From: Clare Sutton (MHA) [REDACTED]
Sent: 21 March 2018 11:42
To: Simon Davis
Cc: Mark Coates; Nat King-Smith (MHA)
Subject: RE: AL/8/18/PL Barnett Close

Barnett Close –

location plan &
proposed site plan

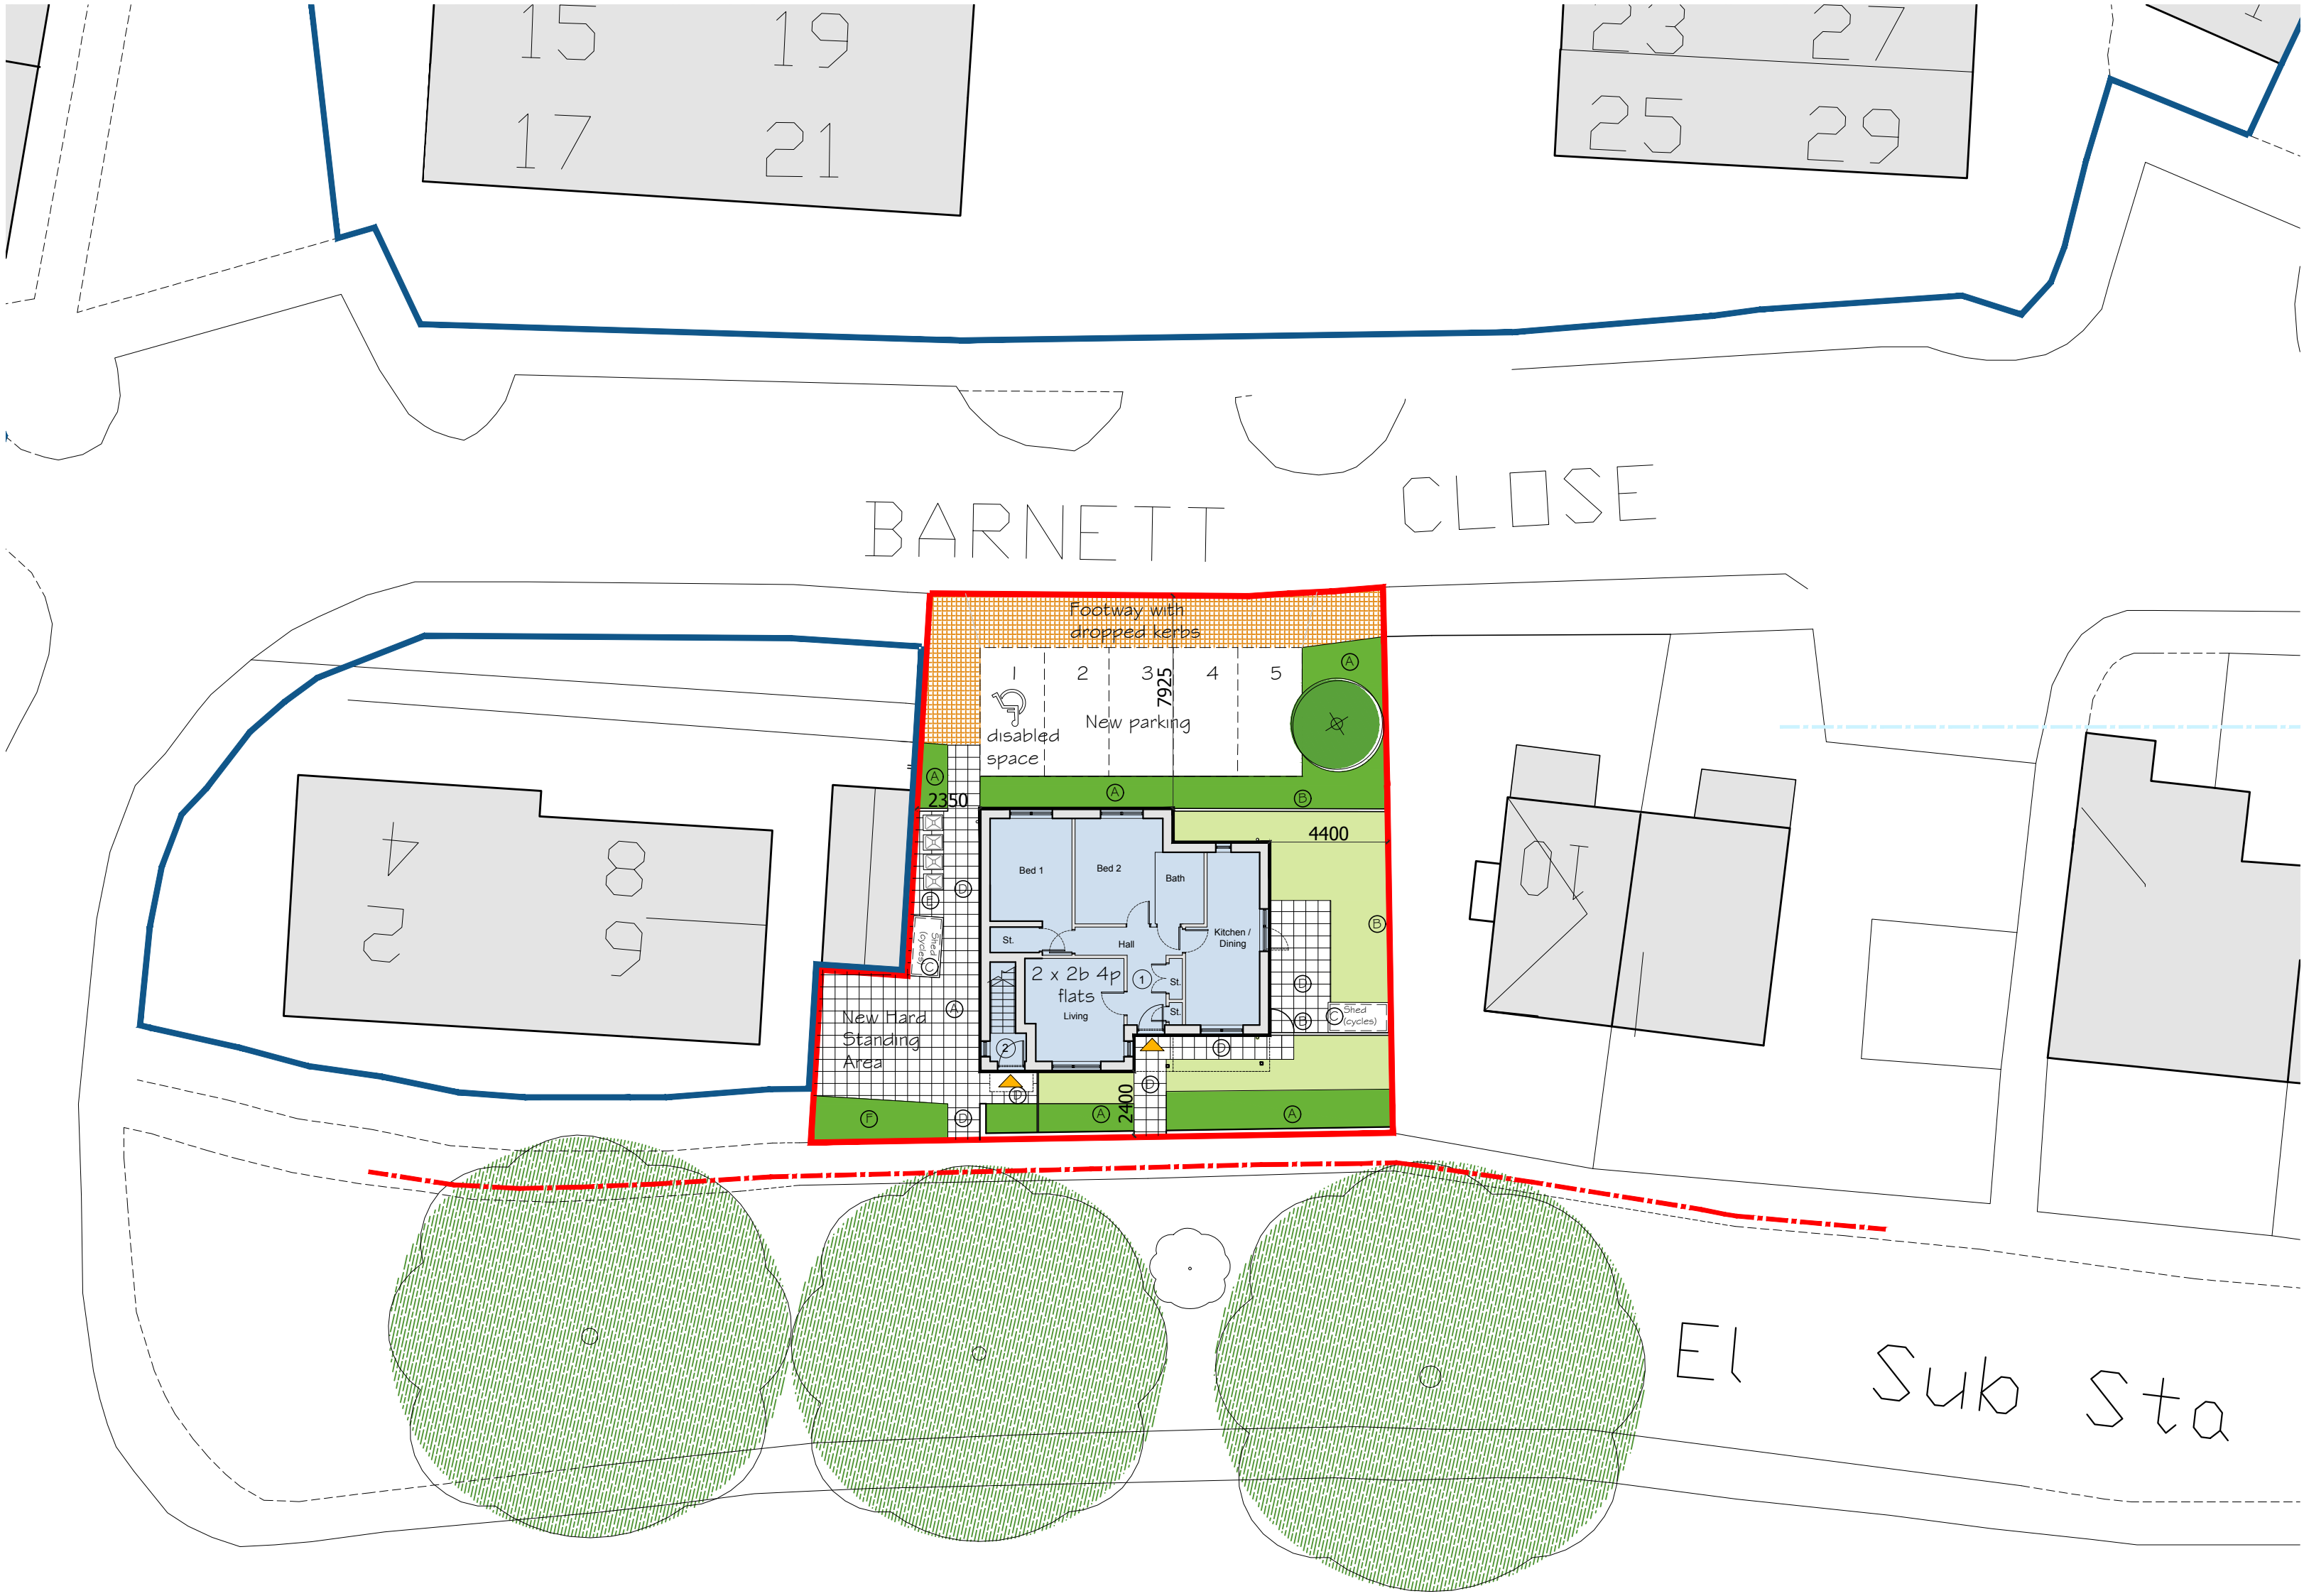
Loss of parking

Loss of washing line area

There are currently 3 parking spaces on the site which will be replaced with 3 unallocated parking spaces in addition to the 2 allocated spaces, for the new flats. Therefore the only loss of parking is for visitors to the new flats which, having checked the parking demand calculator is less than half an unallocated space. The parking survey showed low parking stress in the area but the local residents are expressing concerns over loss of parking. If you feel that these concerns are valid we could make all 5 spaces unallocated which would effectively be increasing the parking on the site. Or as a last resort we could add a space where we currently have landscaping but it would be a shame to lose a future tree.

The site plan shows a new hardstanding area which is intended to be a shared drying area on the south side of the site.
